# CITY OF ALBUQUERQUE

December 4, 2018

**RE: Westgate Community Center  
10001 DeVargas Rd SW  
Conceptual Grading and Drainage Plan  
Engineer's Stamp Date: 11/30/18  
Hydrology File: M09D030**

**GRADING AND DRAINAGE - EAST**

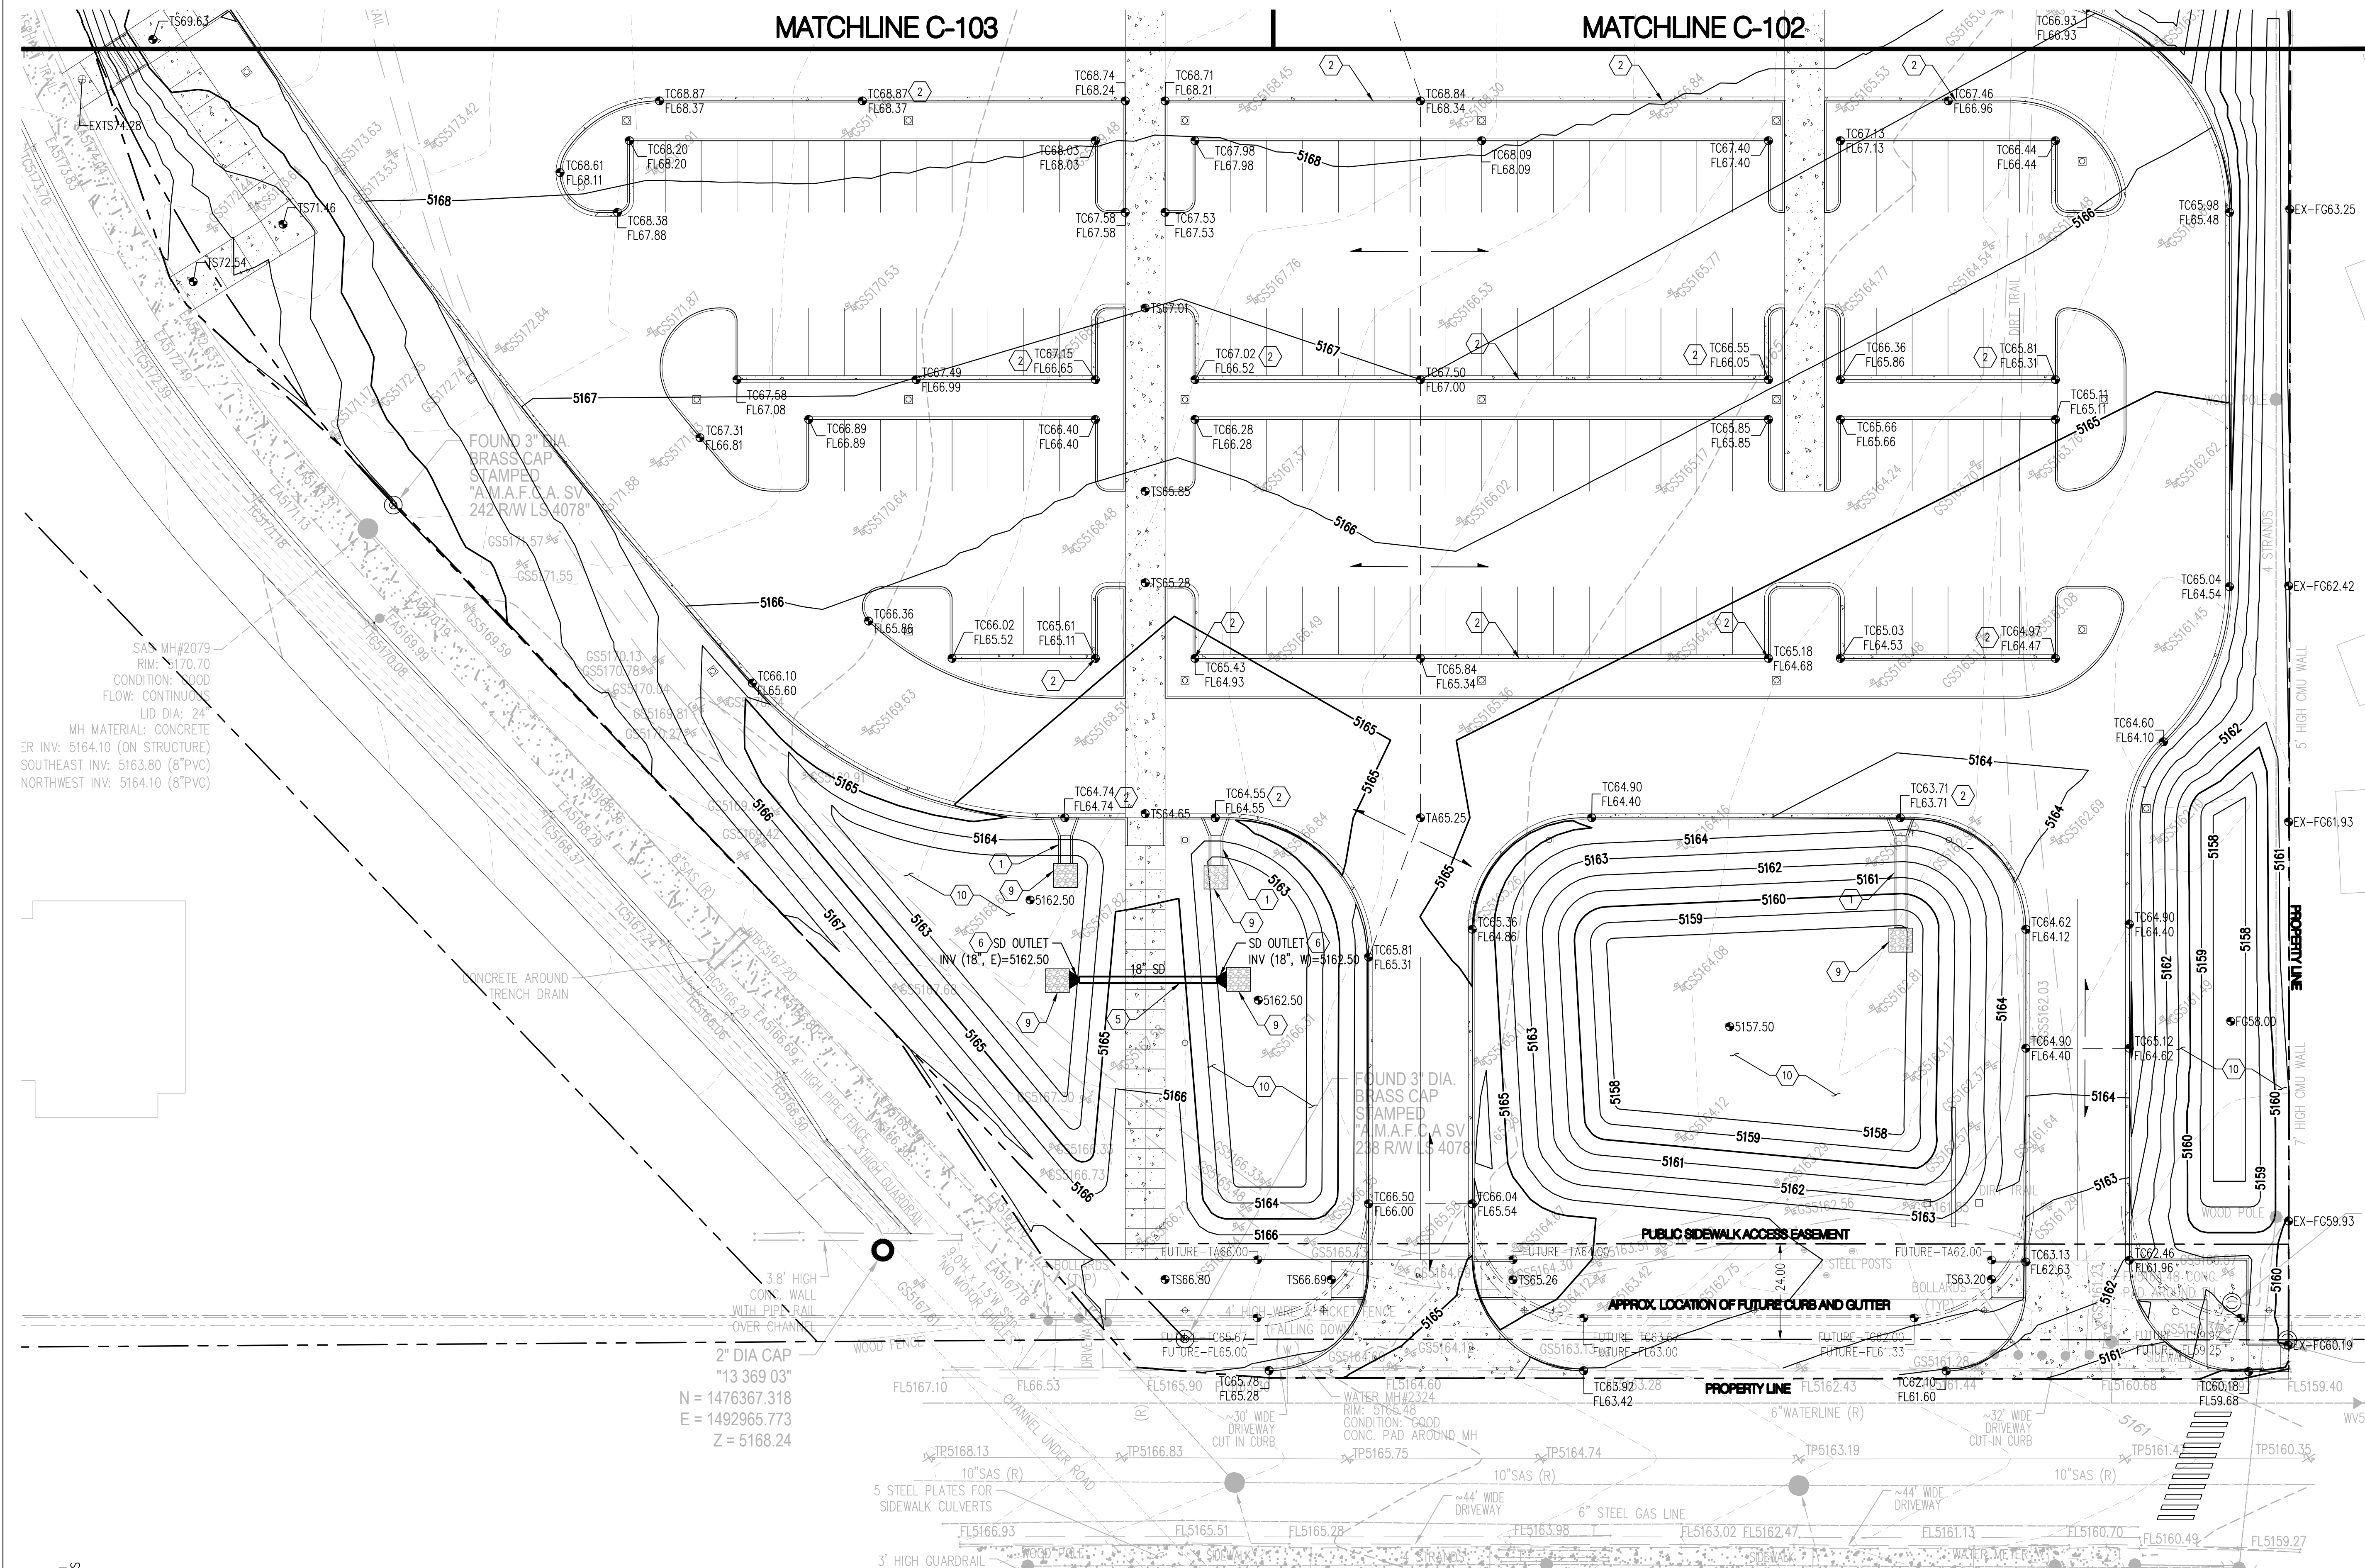
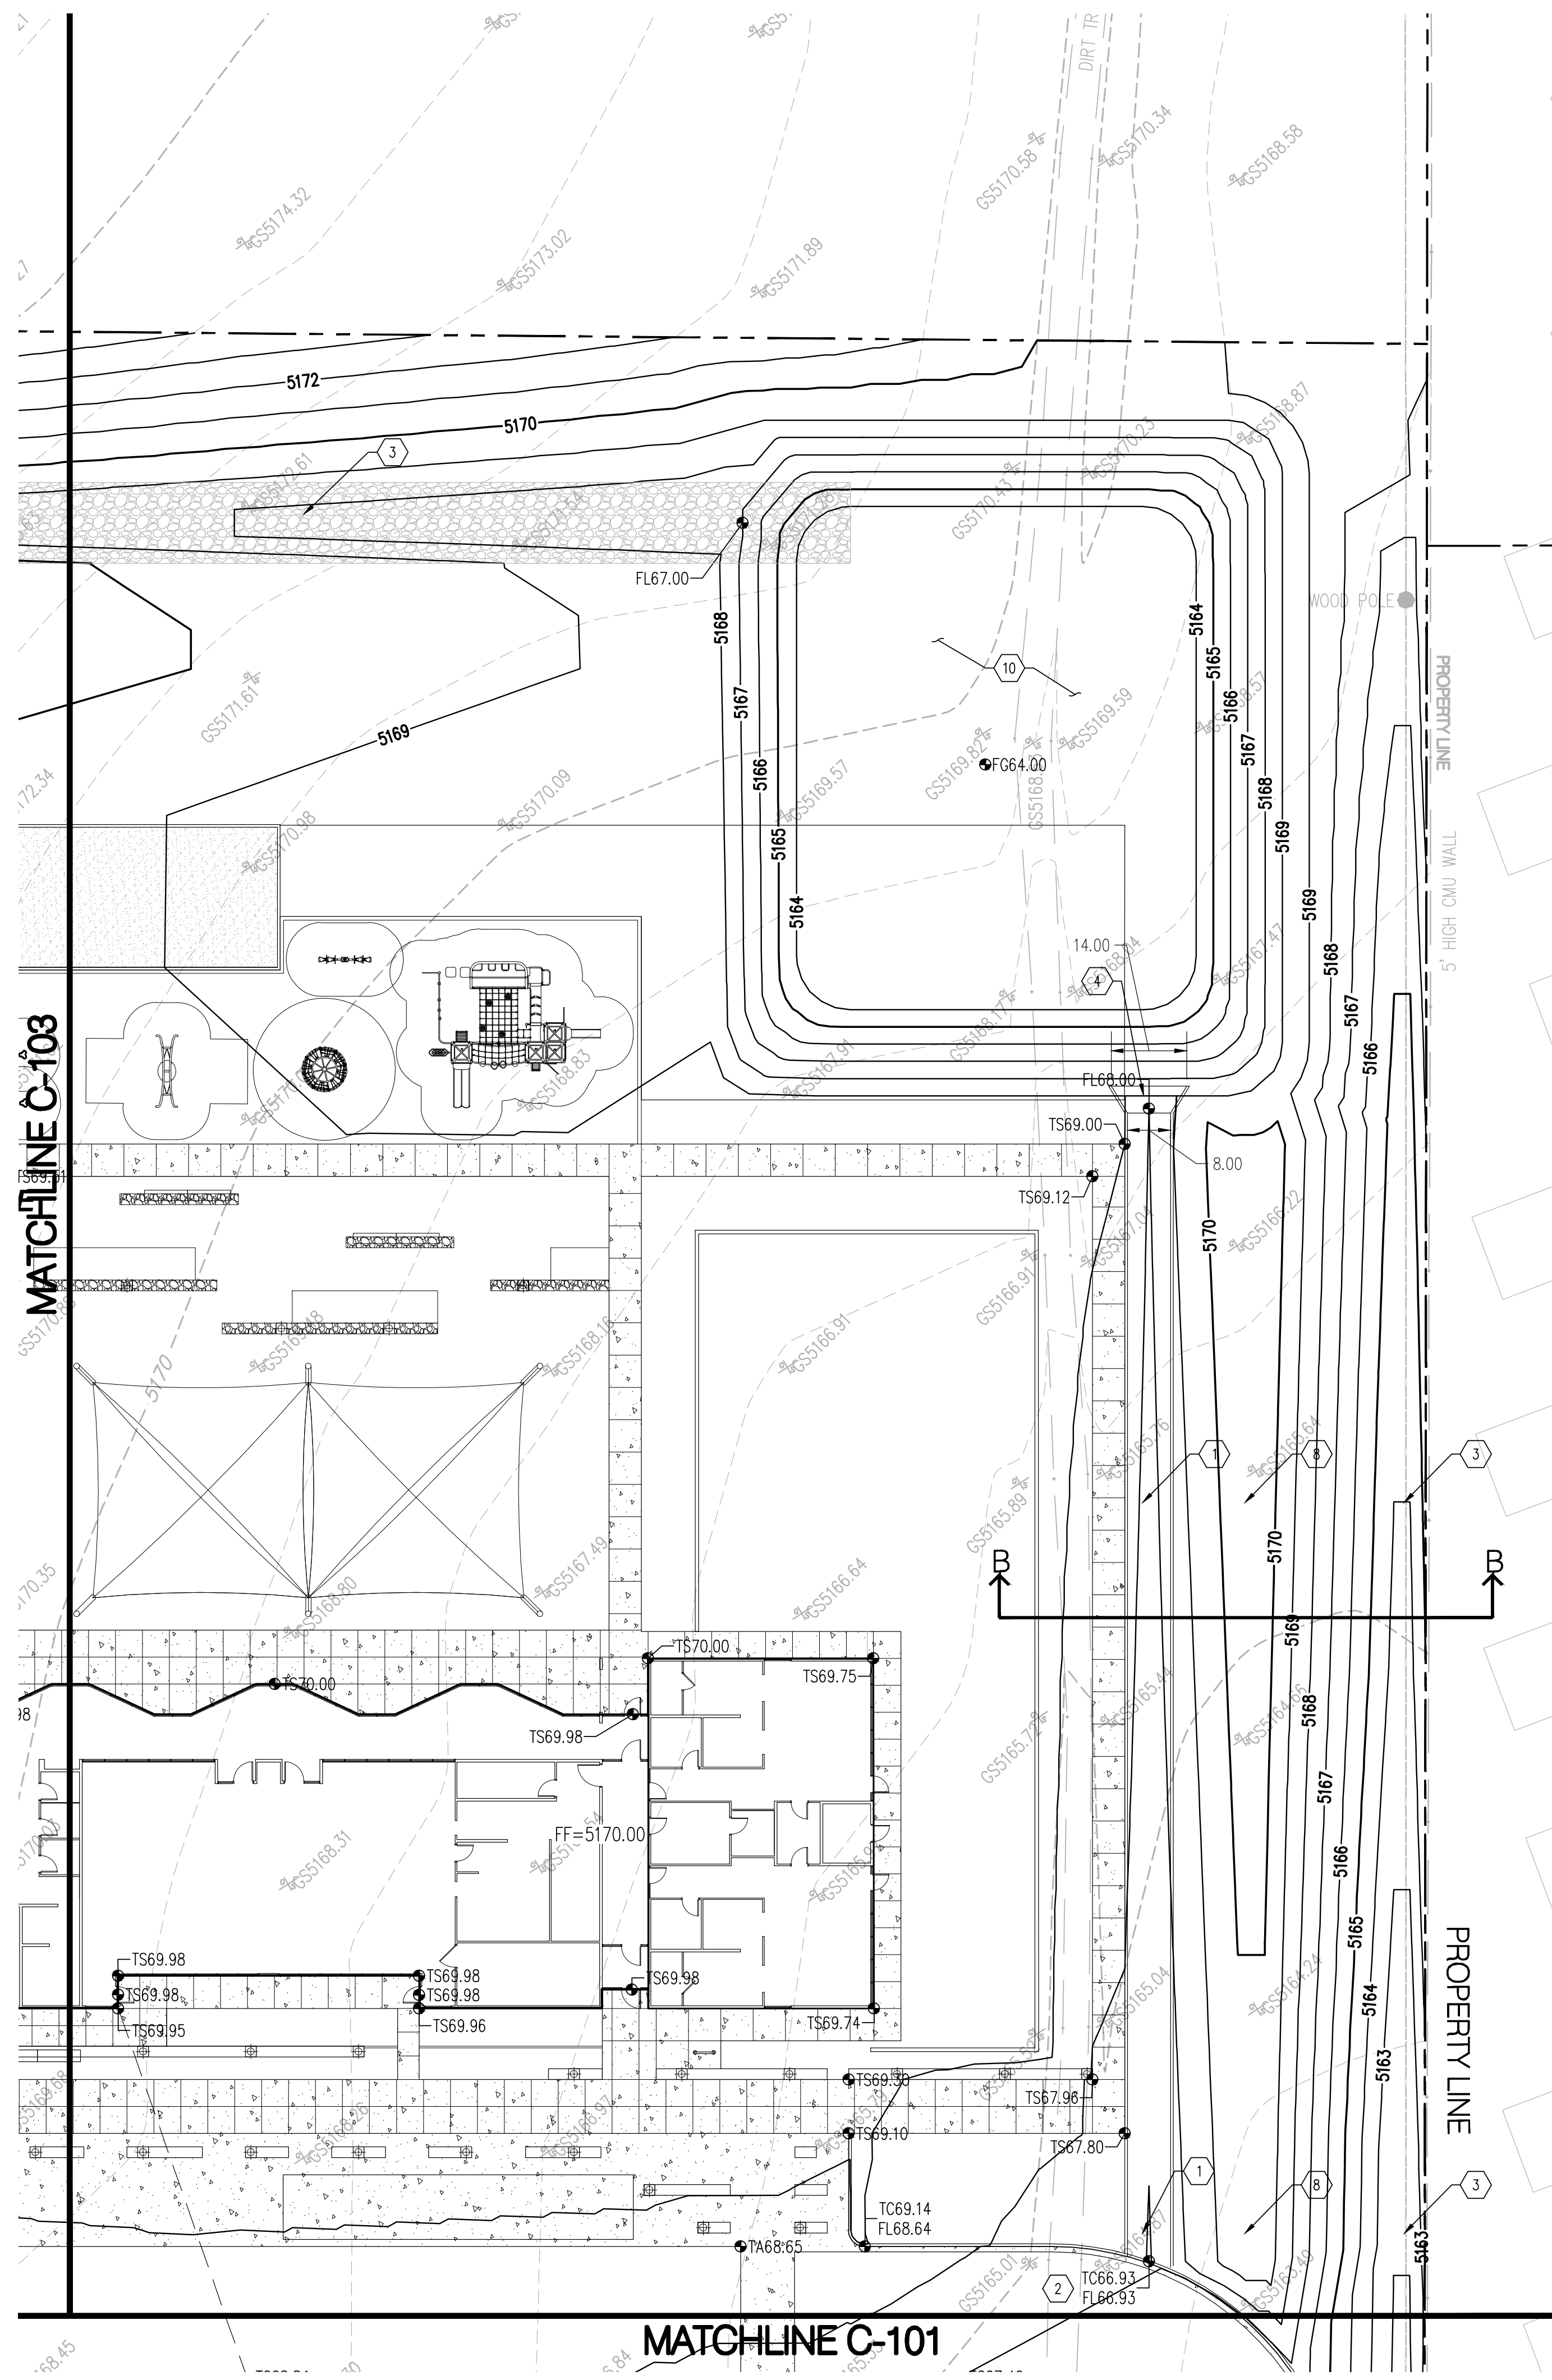
1. Specify Std Dwg 2260 for the ribbon channels.
2. Because Pond 4 retains more than the 100-yr, 10day volume for the contributing area, it doesn't need an emergency spillway (the channel out to DeVargas). This should be removed as it conflicts with the proposed and future built-outs of DeVargas and its sidewalk.
3. Correct the grading around the SE corner of Pond 4, especially the 5160' contour.
